## Springwell Solar Farm – Deadline 1 Submissions

On behalf of Springwell Energyfarm Limited (the 'Applicant') and further to the publication of the **Rule 6 letter** [\[PD-005\]](#) on 9 April 2025 and the **Rule 8 letter** [\[PD-006\]](#) on 13 May 2025, we write to provide the Applicant's written submissions for Deadline 1 of the Springwell Solar Farm Development Consent Order (DCO) Examination.

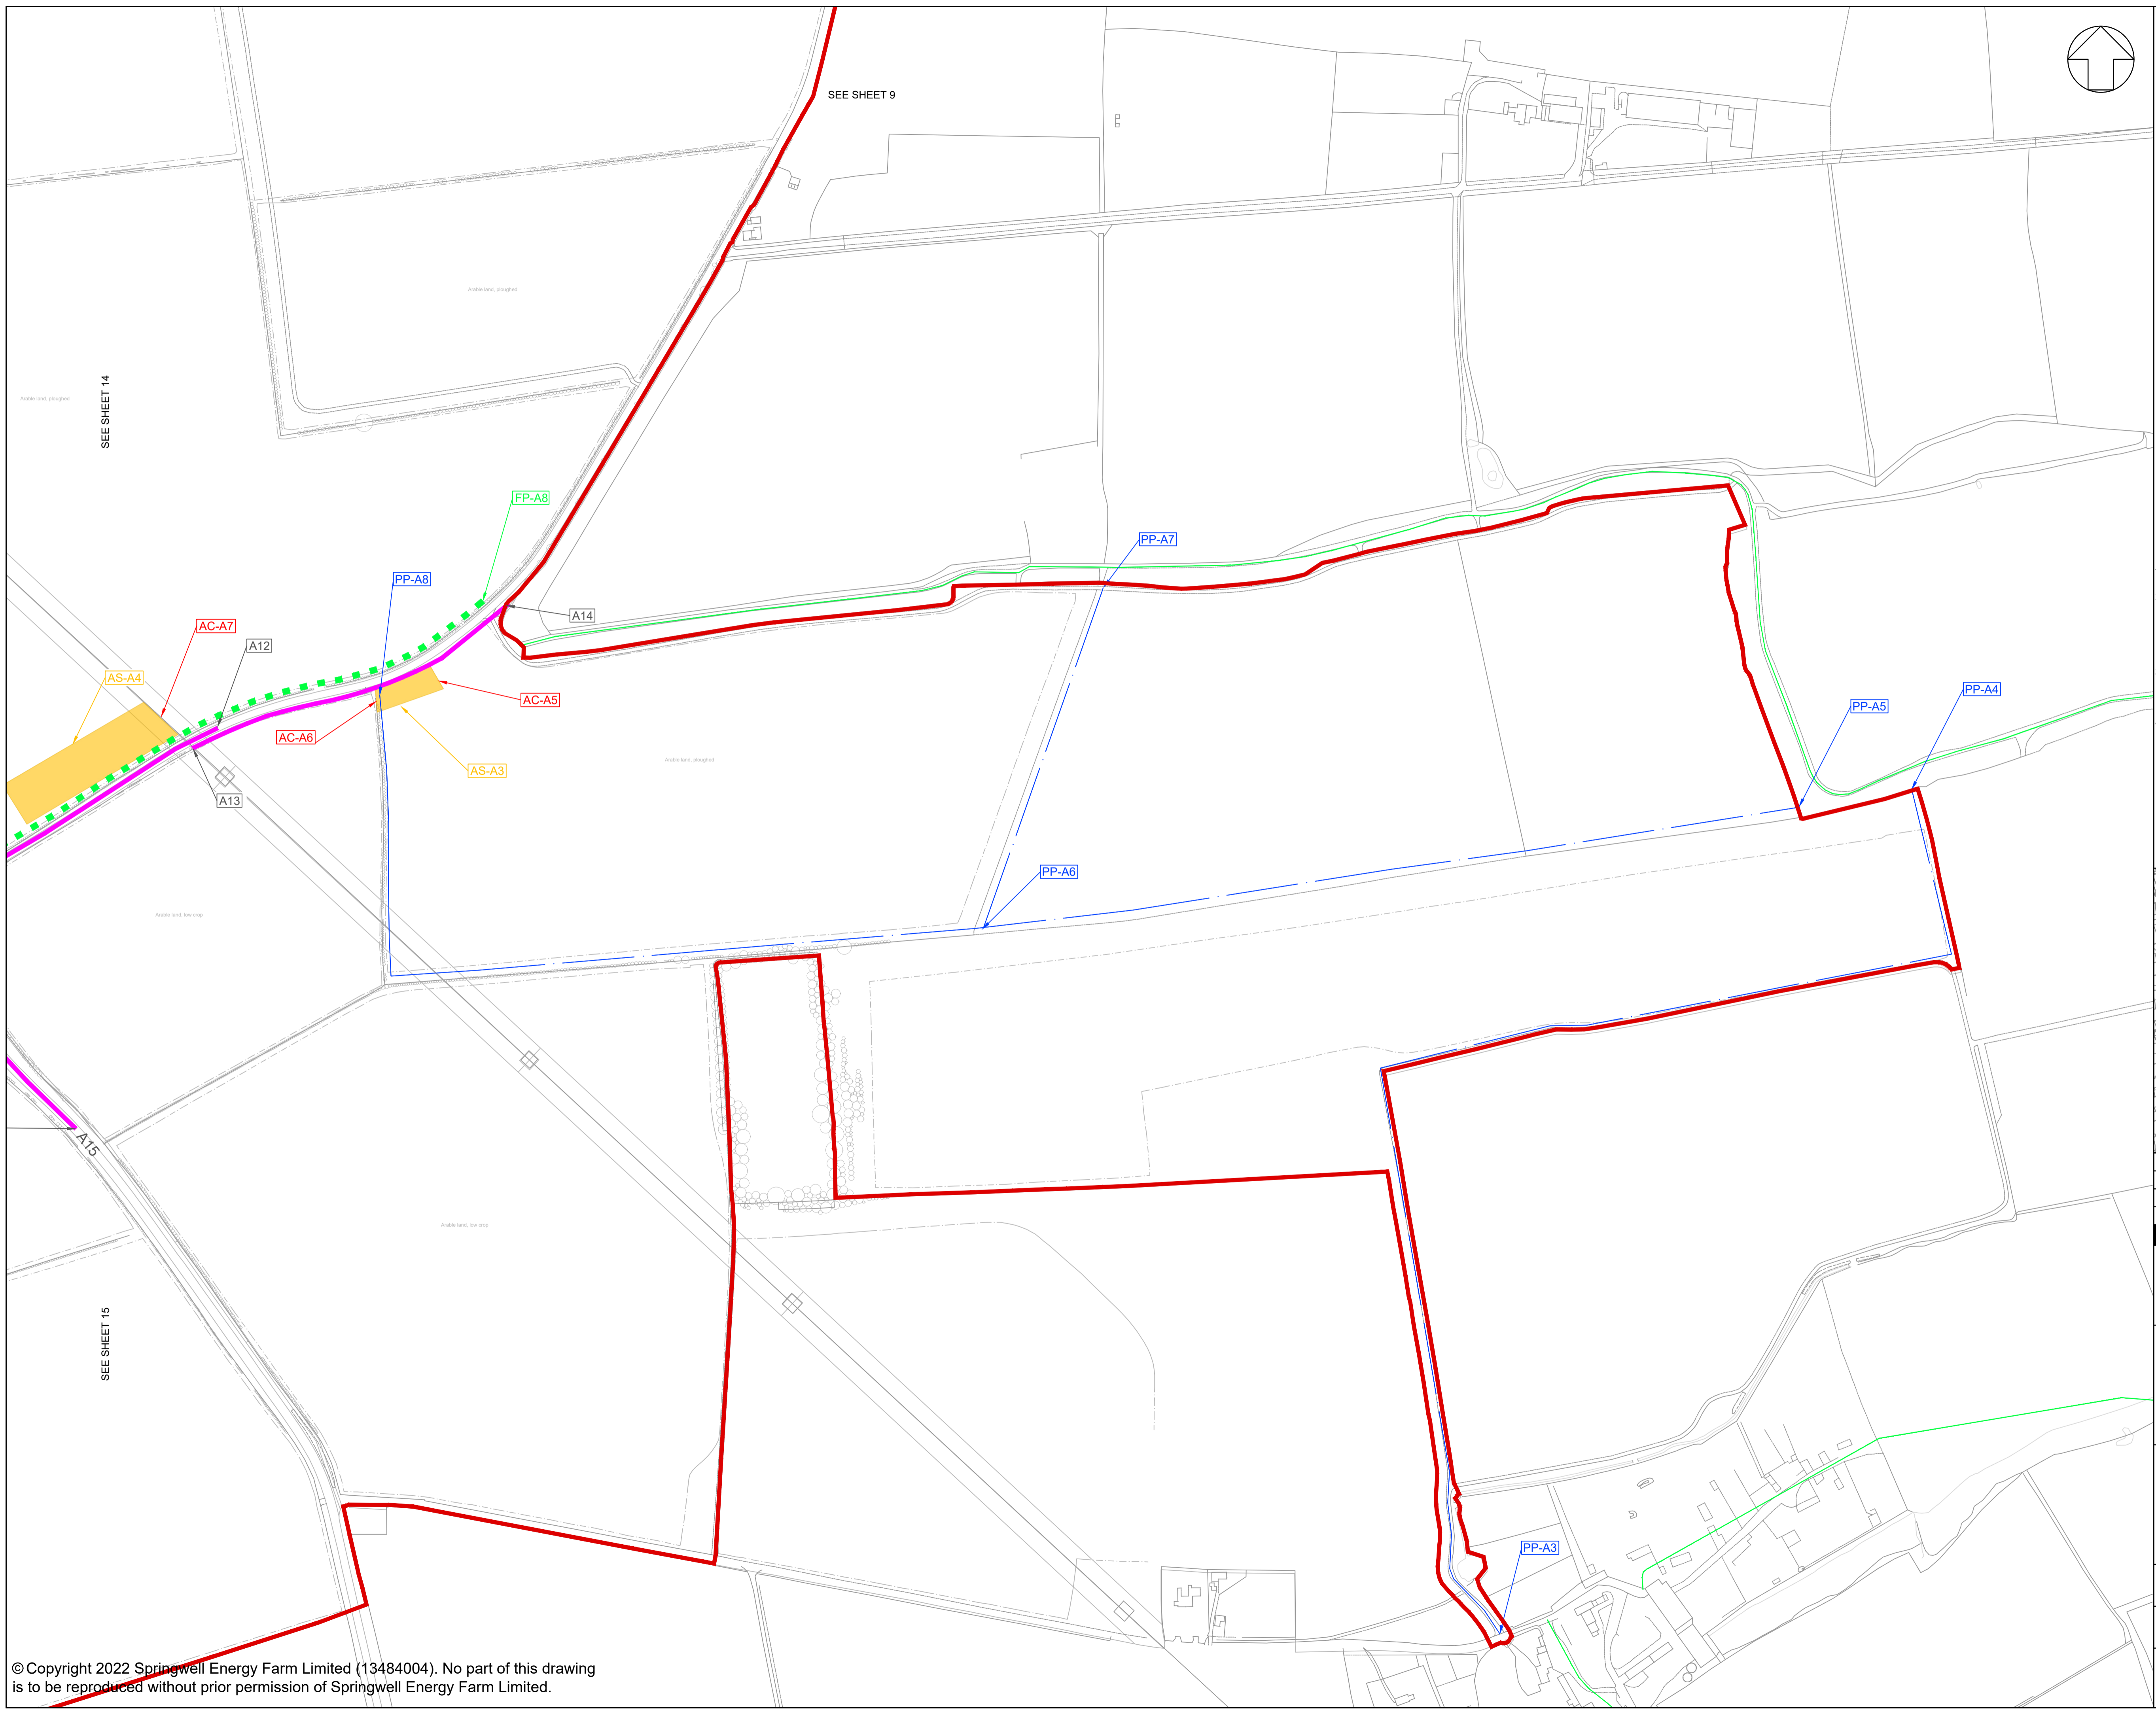
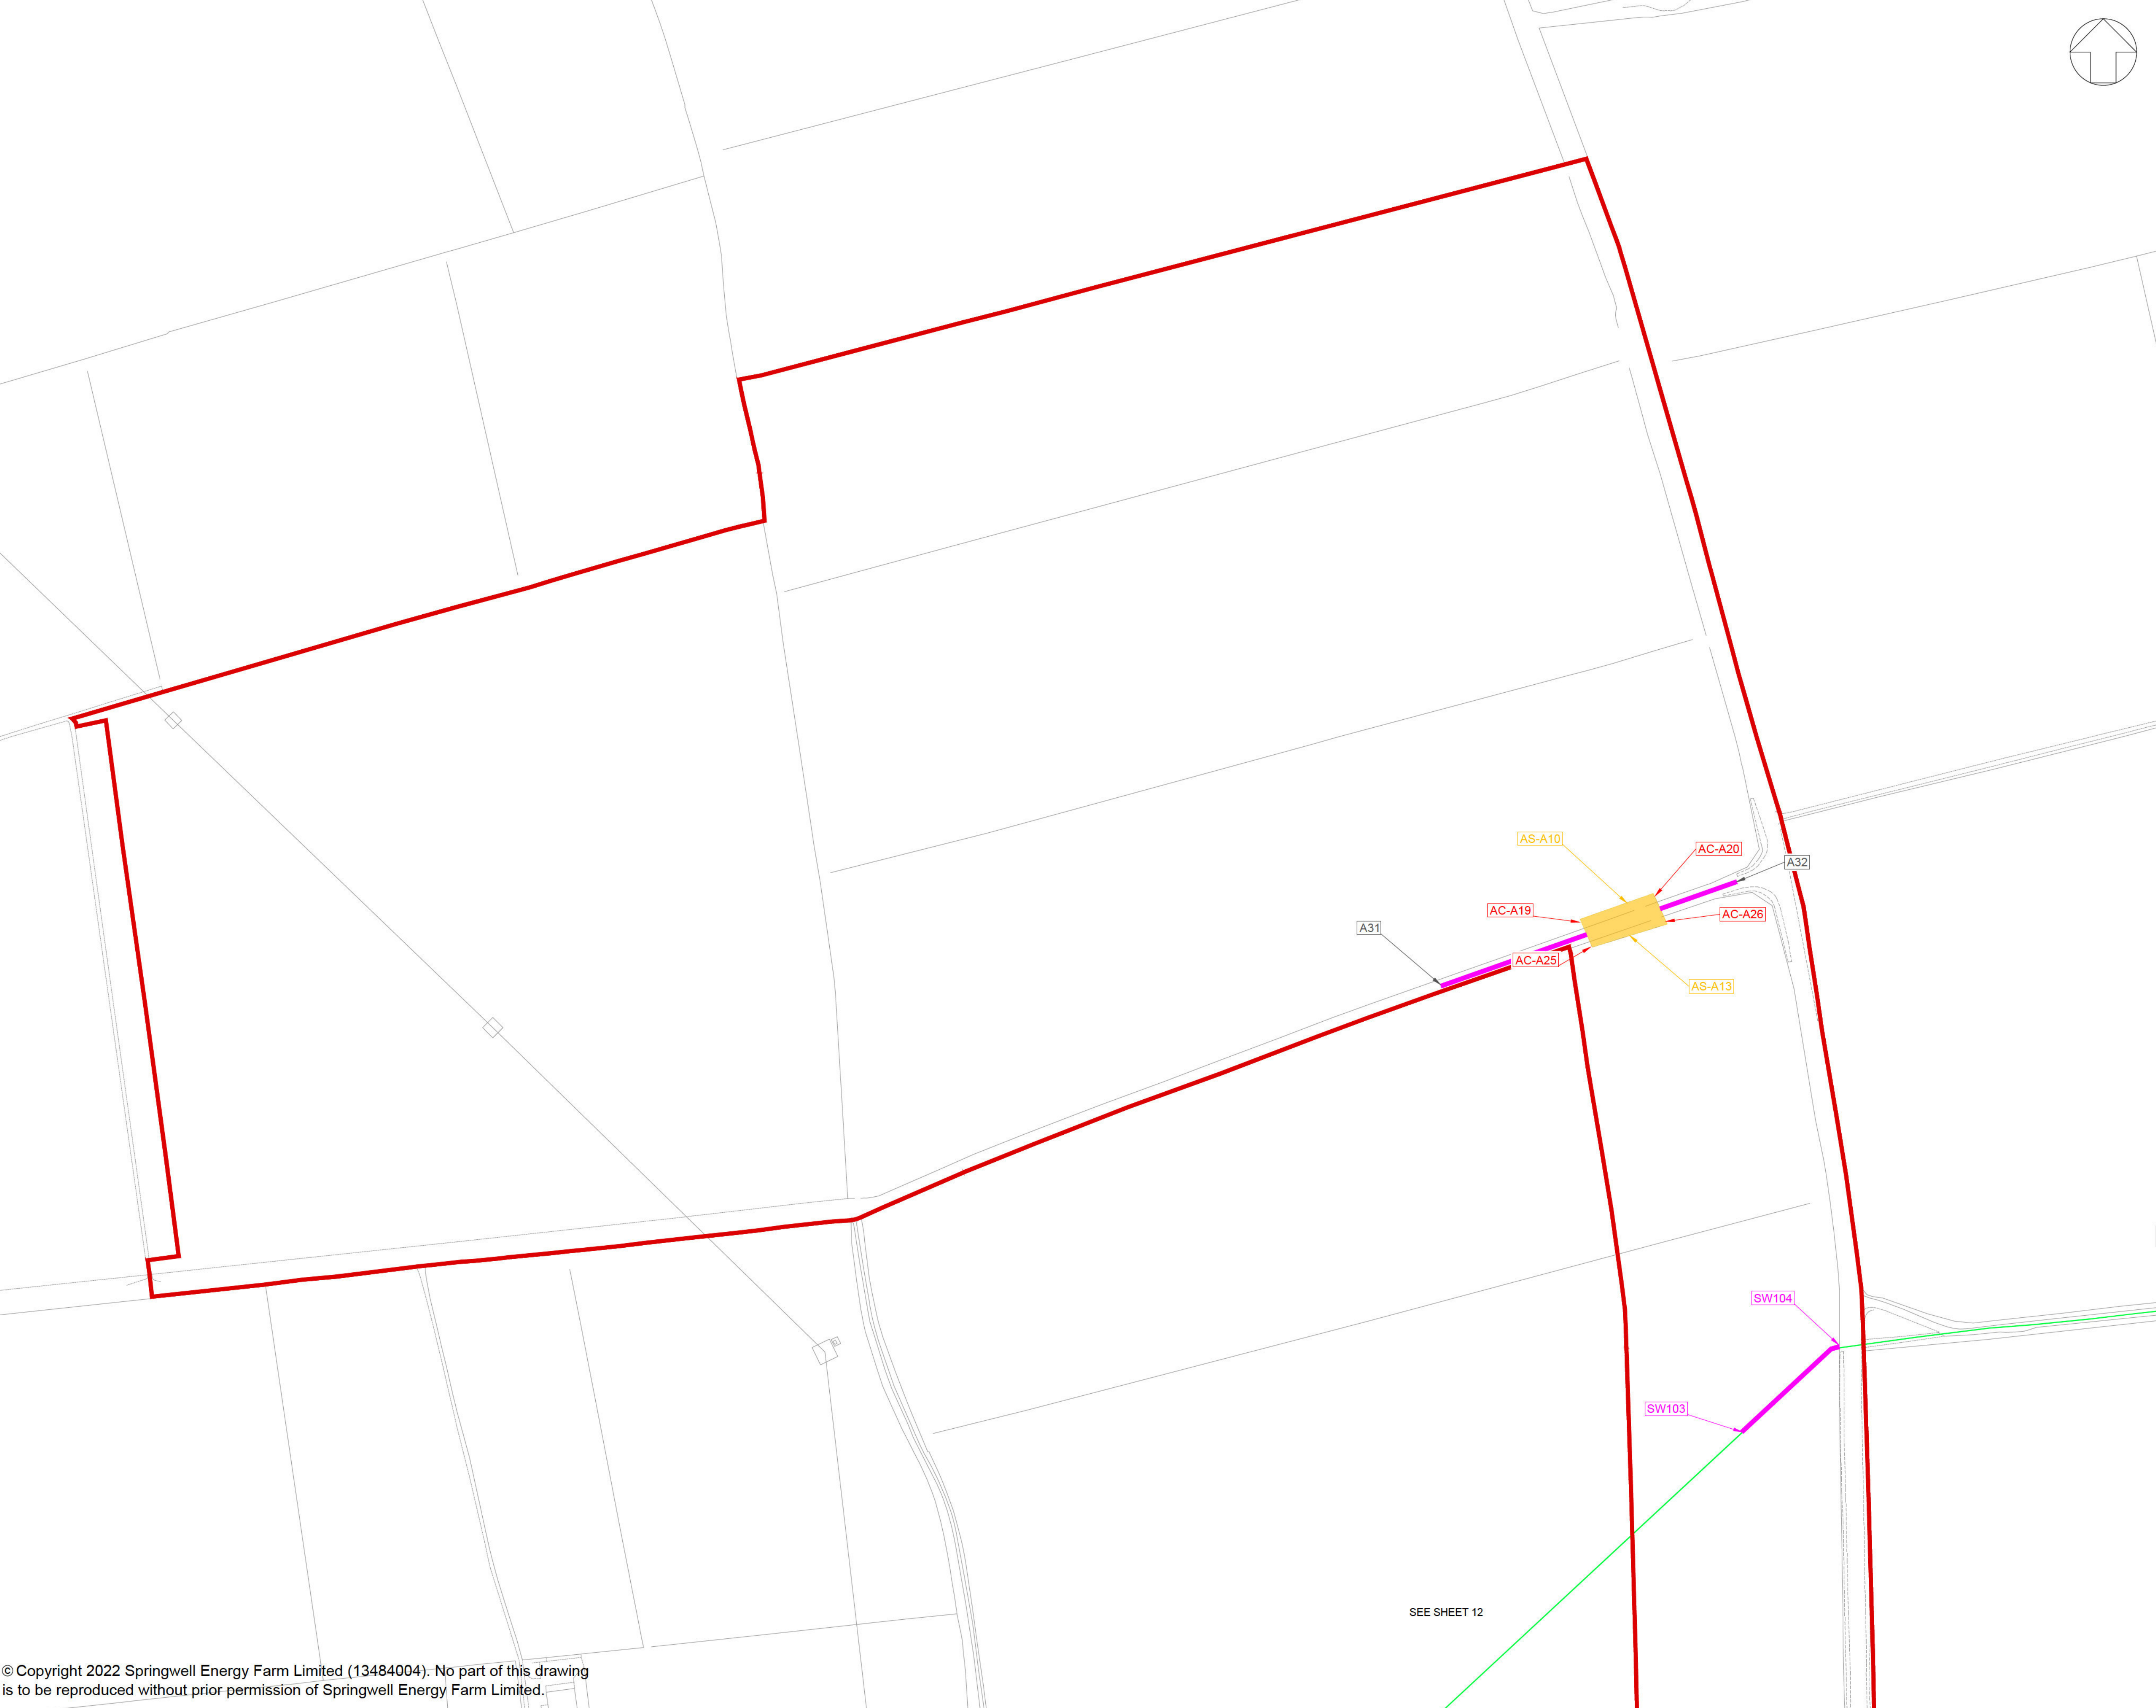
2.4.3	3	Streets, Rights of Way and Access Plans	<p>The green dashed line on Sheet 10 has been adjusted negligibly to clarify that the proposed footpath will align with where the public are understood to exit Bloxholm Wood, following the minor discrepancy raised by Lincolnshire County Council and in agreement with the landowner. This has always been the intent of the proposed footpath as described on p.125 of the Design Approach Document.</p> <p>The solid blue line on Sheet 10 has been corrected to complete the “circular walking loop” permissive path from Bloxholm Wood described on p.125 of the Design Approach Document. The original Streets, Rights of Way and Access Plan showed a road crossing to the public right of way in error. This correction has been agreed with Lincolnshire County and the landowner.</p> <p>The Applicant considers these do not constitute a change to the application. Interested parties will have the opportunity to comment as part of the examination process and there are considered to be no other unregistered parties who may be affected by the clarification and correction.</p>
